Your ref:
Our ref: 22/02027/F
Please ask for: Luke Swales
Direct dial: 01553 616865
E-mail: borough.planning@west-norfolk.gov.uk

16 November 2022

Details: **front extension to create garage and installation of extended drop curb. at Anvil
Main Road Three Holes Norfolk PE14 9JR**

1:100 Proposed Ground Floor Plan

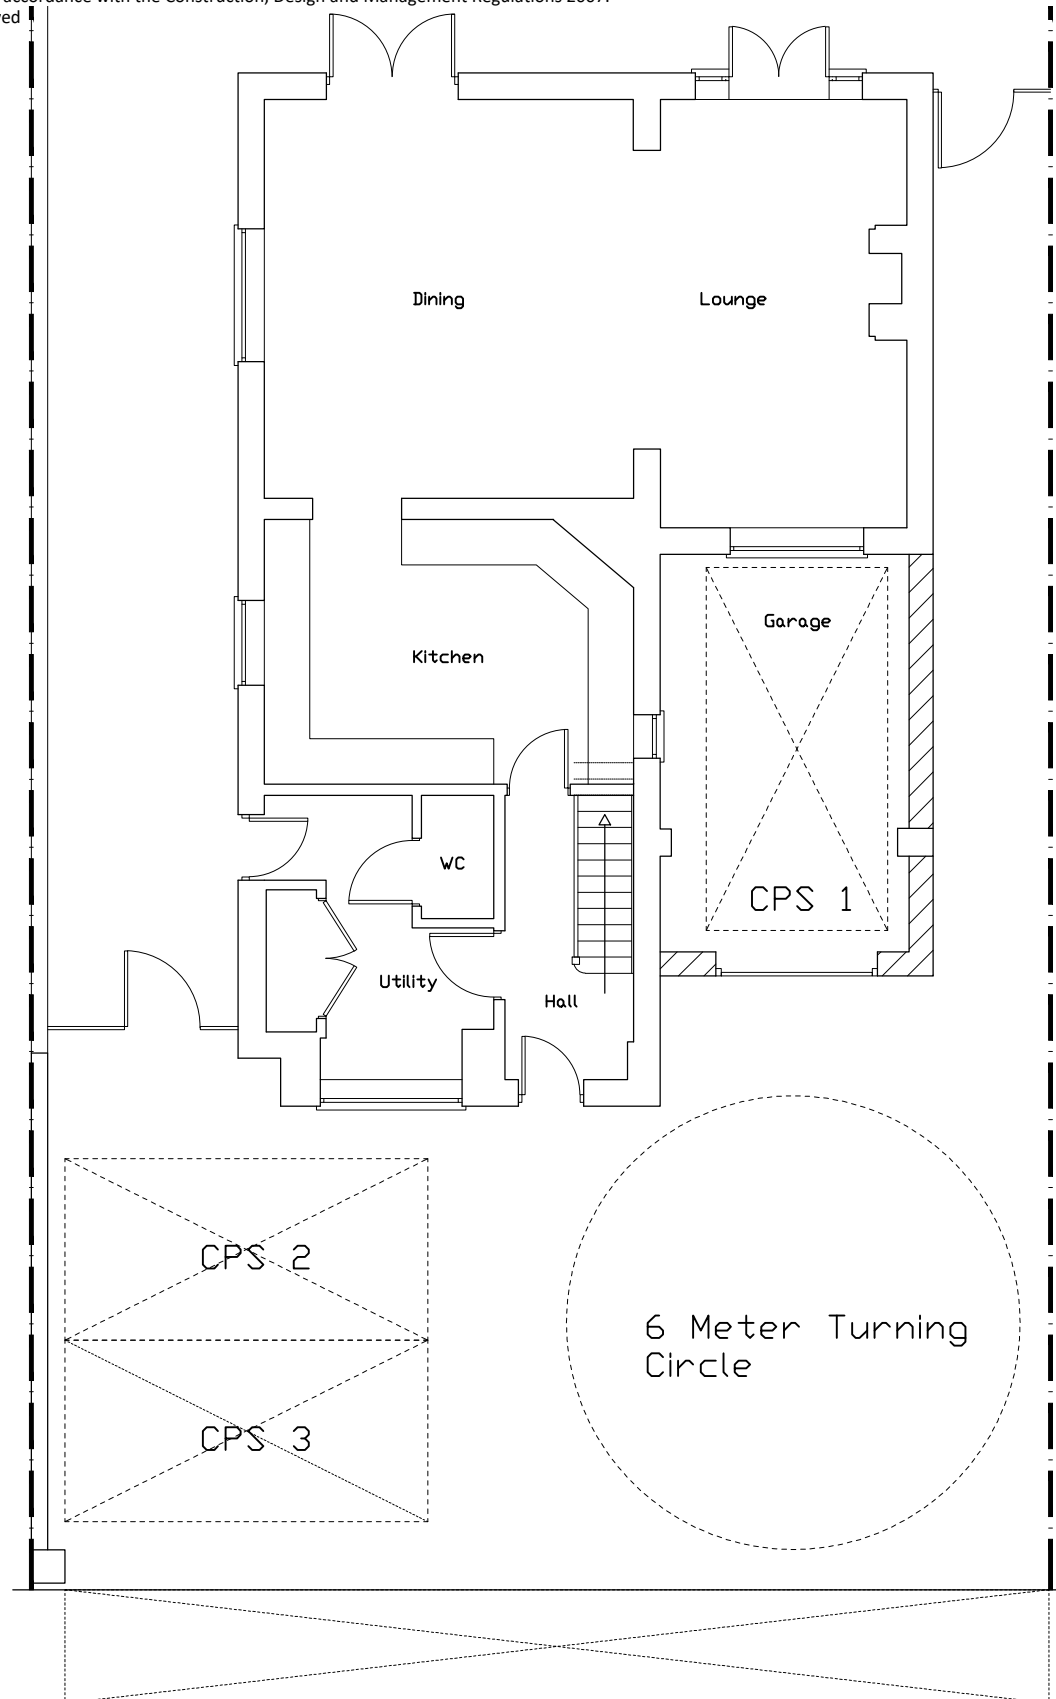
1. As part of the proposal is for the installation of a new dropped curb, a full application form is required, this cannot be done under a householder application. Please submit a full application form. When filling in the form, please ensure that it is filled in correctly with boxes for applicant ticked where applicable instead of agent as you are not using an agent. For example, on the ownership certificate make sure that it is signed by the applicant and not the agent.
2. The fee for a dropped curb is £234 and the fee for a householder is £206. This means that there is an outstanding balance of £28 to pay. Please make arrangements to pay this fee. This does not affect the proposal for this application as the dropped curb and the garage can be done under the same full application.
3. Please confirm the width and the exact size and position of the new access as part of this application.
